M42 Junction 6 Development Consent Order Scheme Number TR010027

8.99 Response to the ExA's Commentary on the dDCO

Response to the ExA's Commentary on the dDCO

**INDICATIVE PROPOSAL FOR MAIN COMPOUND AND OFFICES FOR M42 J6 SCHEME**

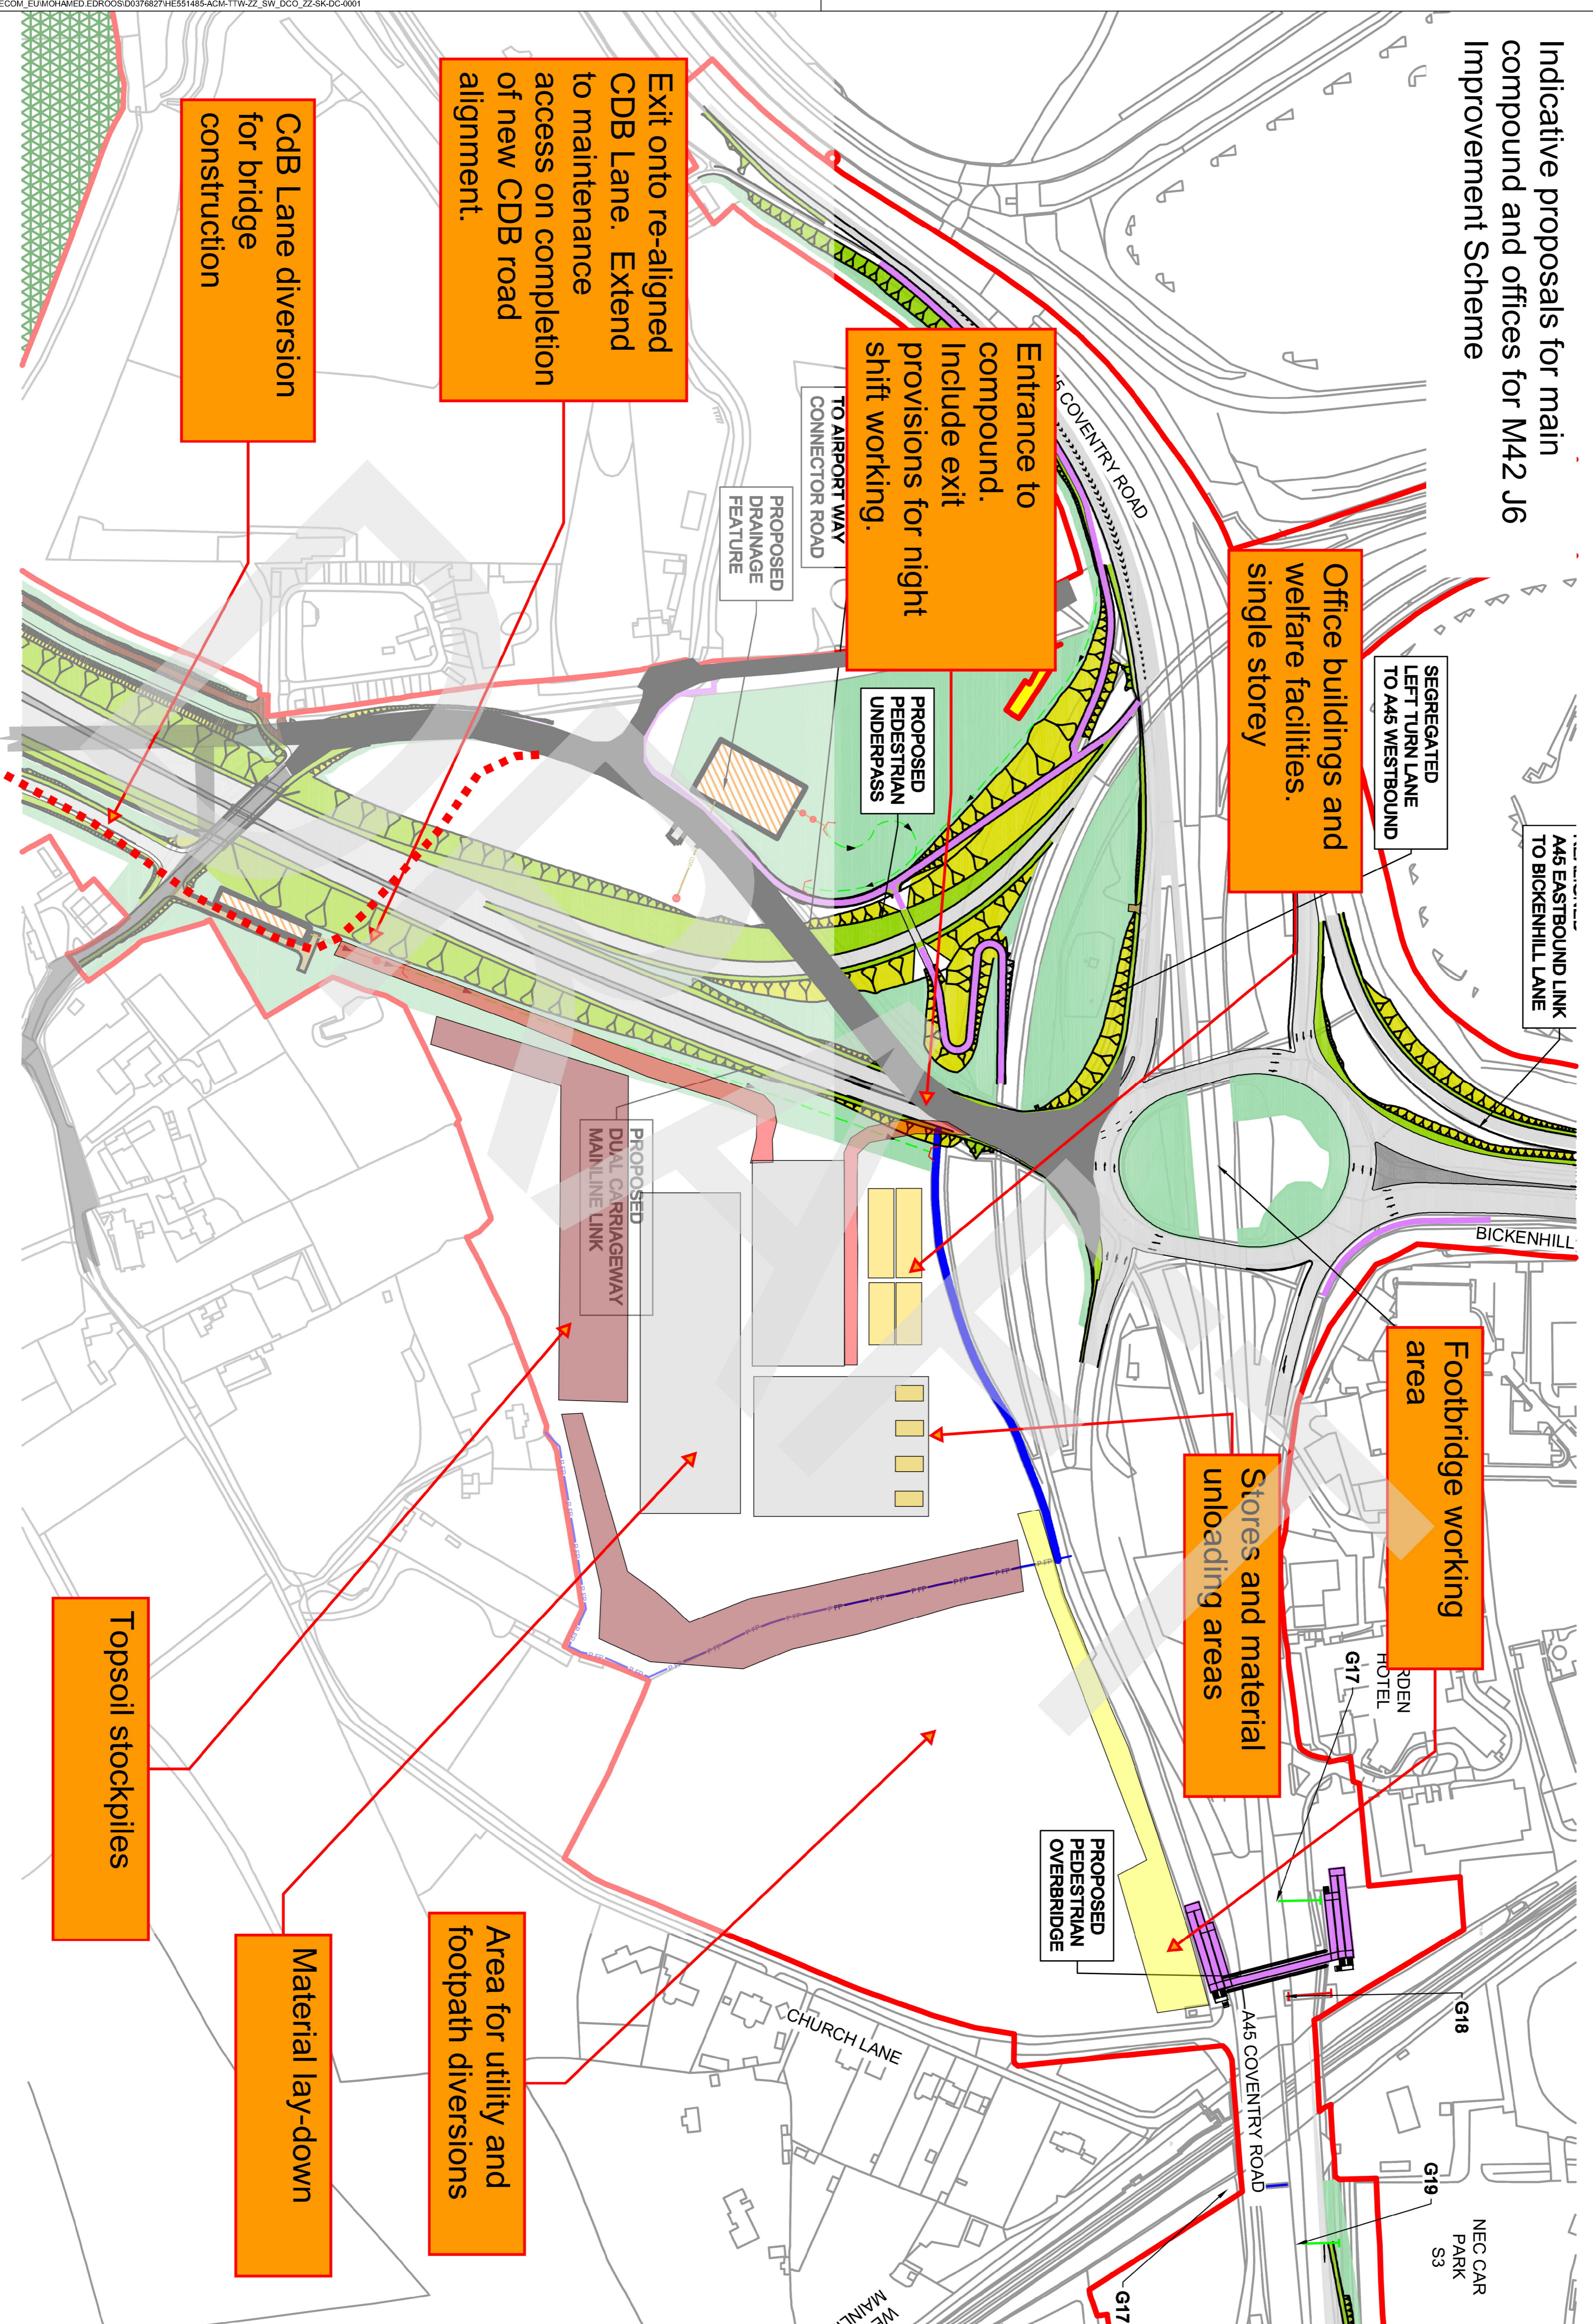
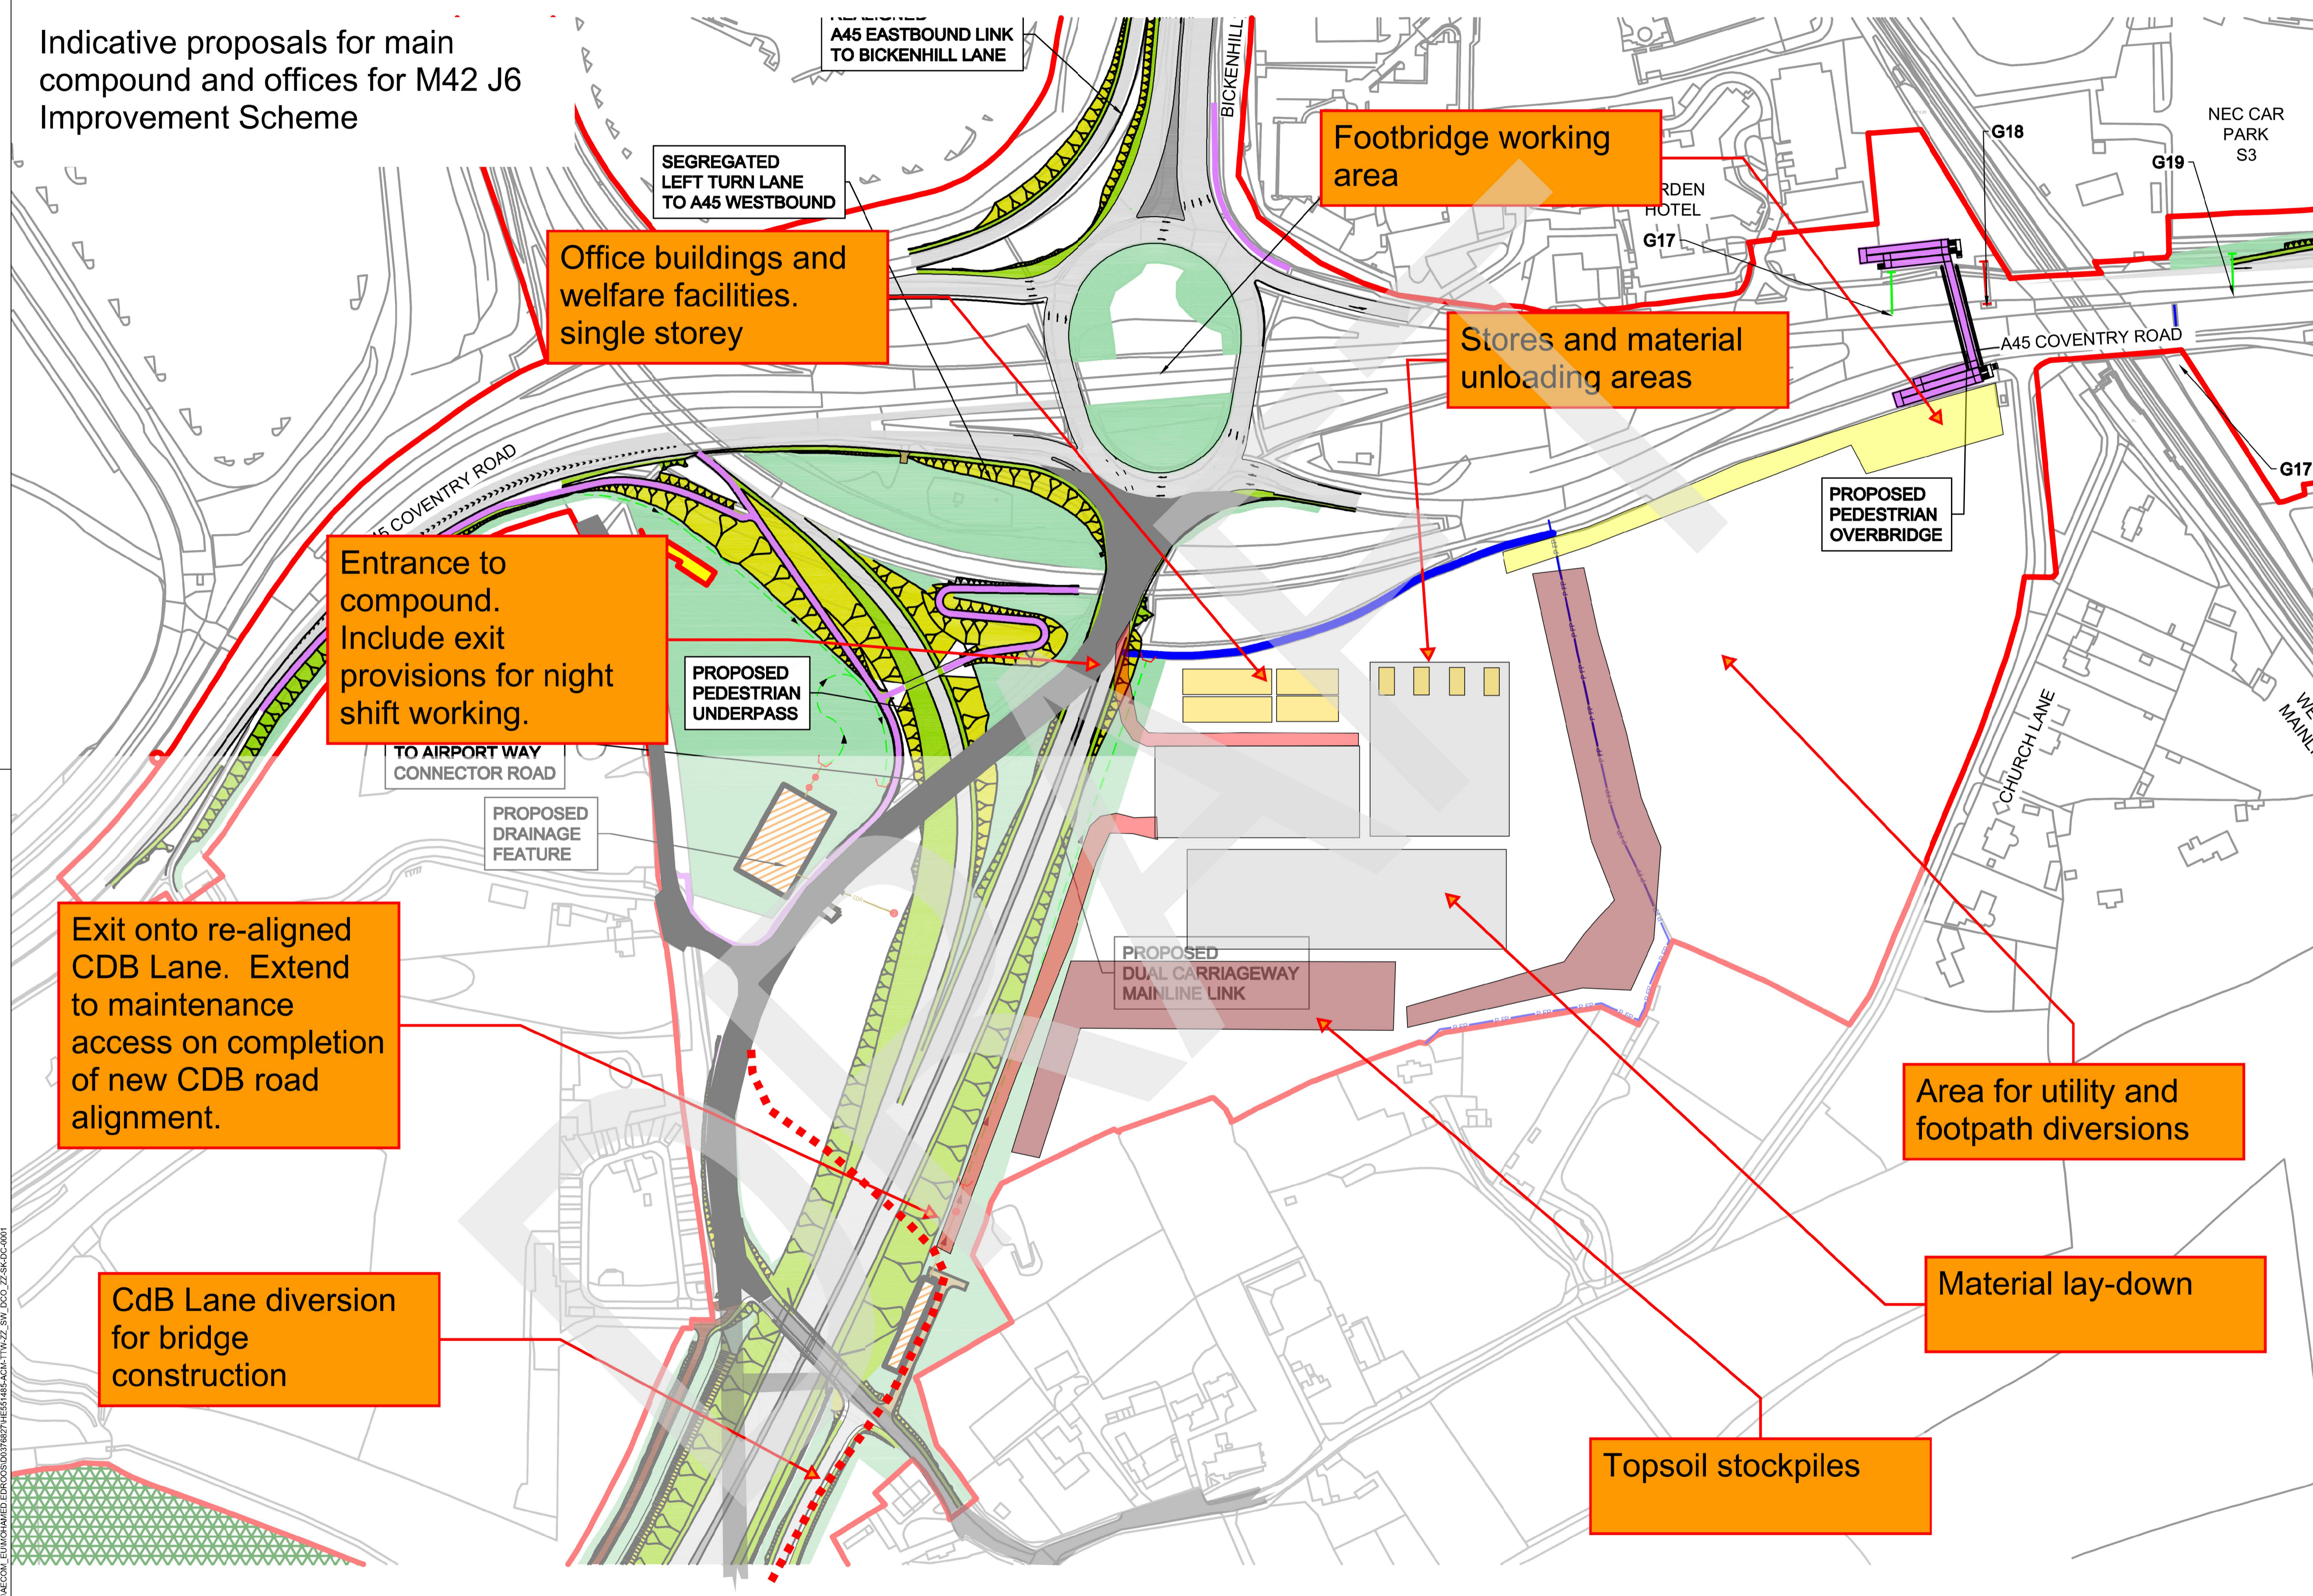
Item Number	Commentary, Response Sought and the Applicant's Response	
9	<p>Requirement 4</p> <p>Outline Compound Management Plan. Appendix 1: Indicative proposal for Main Compound and Office for the Scheme</p>	<p><u>ExA's Commentary</u></p> <p>The 'Indicative Proposal for Main Compound and Office for the Scheme' replicates the initial arrangement set out at D3A [REP3A-003] rather than the alternative configurations put forward at D6 (REP6-015 – page 13) and D7 (REP7-011 – Appendix 1, Page 2 of 2).</p> <p>It was agreed that an alternative configuration was possible with an entrance and exit onto Catherine-de-Barnes Lane at the northern end of the compound (Figure 1 at Action No.4 of REP6-015). Moreover, a plan at page 13 in the same section of the same document details how the compound could be reconfigured to the north and east to increase the buffer significantly between the compound perimeter and the adjacent properties on Church Lane. Although the laydown areas would then be closer to residents at the north east of Church Lane, they would be screened by existing trees and hedgerows and the proposed stockpile bunds as shown in the cross sections on page 2 of Appendix 1 of REP7-011.</p> <p>The ExA recognise that this configuration might require a right turn from the northern exit to be prohibited and the installation of traffic lights there and additional phases in constructing the main line link road. However, the scale of the embankments and earth moving required for the scheme suggested in EV-040 could be prohibitive.</p> <p><u>Response sought from:</u> The Applicant, SMBC, Bickenhill and Marston Green Parish Council, Mr Philip O'Reilly, Heath Cotterill, Camila Burton and David Cuthbert</p> <p>The following amendment is therefore proposed (see also new R14 below):</p> <p>Substitute the existing Plan at Appendix 1 of the Outline Compound Management Plan [REP8-009] with the plan shown at Action No.4 of REP6-015 (page 13) detailing how the compound could be pushed further to the north and east to increase the buffer and as also shown in the cross sections on page 2 of Appendix 1 of REP7-011.</p> <p><u>The Applicant Response:</u></p> <p>In accordance with the ExA's request, the Applicant has substituted the plan in Appendix 1 of the Outline Compound Management Plan. This is now included in the updated Outline Environmental Management Plan (OEMP) submitted at Deadline 9 [Volume 6.11(a)]. Furthermore, the Applicant has included an additional commitment within the Register of Environmental Actions and Commitments (REAC) within the updated OEMP as follows:</p>

Item Number	Commentary, Response Sought and the Applicant's Response	
		<p><i>G4b</i></p> <p><i>So far as reasonably practicable, Highways England and/or the PC will design and layout the main site compound to reduce potential impacts on the residents of Bickenhill. This will include arranging the site in such a way so it is compatible with the layout shown in Appendix 1 to the Outline Compound Management Plan.</i></p>
10	Requirement 9 Archaeological remains	<p><u>ExA's Commentary:</u></p> <p>Discussions are underway with SMBC on the wording that could be added to R9. It is agreed that the Written Scheme of Investigation is the best document to include such detail.</p> <p>The ExA welcome this agreement.</p> <p><u>Response sought from: The Applicant and SMBC</u></p> <p>We look forward to receiving the final Written Scheme of Investigation and any consequent changes to the DCO at D9.</p> <p><u>The Applicant Response:</u></p> <p>The Applicant had not proposed to produce a 'final' Written Scheme of Investigation (WSI) at this stage, as this will be prepared in advance of commencement of works, following consultation with SMBC in accordance with Requirement 9. The Applicant does not intend that the final WSI should be a certified document.</p> <p>The Applicant proposes that the final WSI will be largely based on WSI contained in Appendix 7.1 of the Environmental Statement [APP-123/Volume 7.1]. Having discussed this matter further with SMBC, it is clear that it expects further trial trenching and investigation works to occur beyond that already undertaken. To this extent, and where archaeological remains are discovered the methodology, monitoring, reporting and archiving obligations set out in the WSI in Appendix 7.1 are likely to be replicated in the final WSI.</p> <p>The Applicant and SMBC have also agreed that Requirement 9 should be amended so that it is clear that it applies to areas of <u>potential</u> archaeological interest.</p>

Item Number	Commentary, Response Sought and the Applicant's Response
	<p><u>The Applicant Response:</u></p> <p>The Applicant has sought to address this matter through an additional commitment within the REAC and by updating the Plan in Appendix 1 of the Outline Compound Management Plan which now forms Appendix P of the Outline Environmental Management Plan (OEMP), as updated and submitted at Deadline 9 [Volume 6.11(a)]. Commitment G4b states:</p> <p style="padding-left: 40px;"><i>So far as reasonably practicable, Highways England and or the Principal Contractor will design and layout the main site compound to reduce potential impacts on the residents of Bickenhill. This will include, arranging the site in such a way so it is compatible with the indicative main site compound layout shown in Appendix 1 to the Outline Compound Management Plan</i></p> <p>The Applicant does not consider that a separate Requirement dealing with the layout of the main site compound would be appropriate for inclusion under the policy tests described in Paragraph 15.2 of The Planning Inspectorate's Advice Note 15 'Drafting Development Consent Orders' because:</p> <ol style="list-style-type: none"> 1) there are no significant effects on the residents of Bickenhill associated with the main site compound reported in the Environmental Statement; 2) the Principal Contractor is likely to change the layout of the compound over time, for instance when work starts on Junction 6 and it is not clear whether they would be expected, or even able, to submit a new scheme showing the revised layout; 3) the requirement as drafted may present issues of enforceability; 4) the management measures set out within the OEMP and, in particular, the Outline Compound Management Plan already require the main site compound to be laid out so as to minimise environmental effects, including visual impact, flood risk, effects on sensitive ecology, overlooking and noise. 5) The approval mechanism for this requirement would differ from all other requirements, with variations to the layout having to be agreed by both the local planning authority and the Secretary of State. <p>The Applicant therefore does not consider that Requirement R14 should be included within the draft DCO.</p>
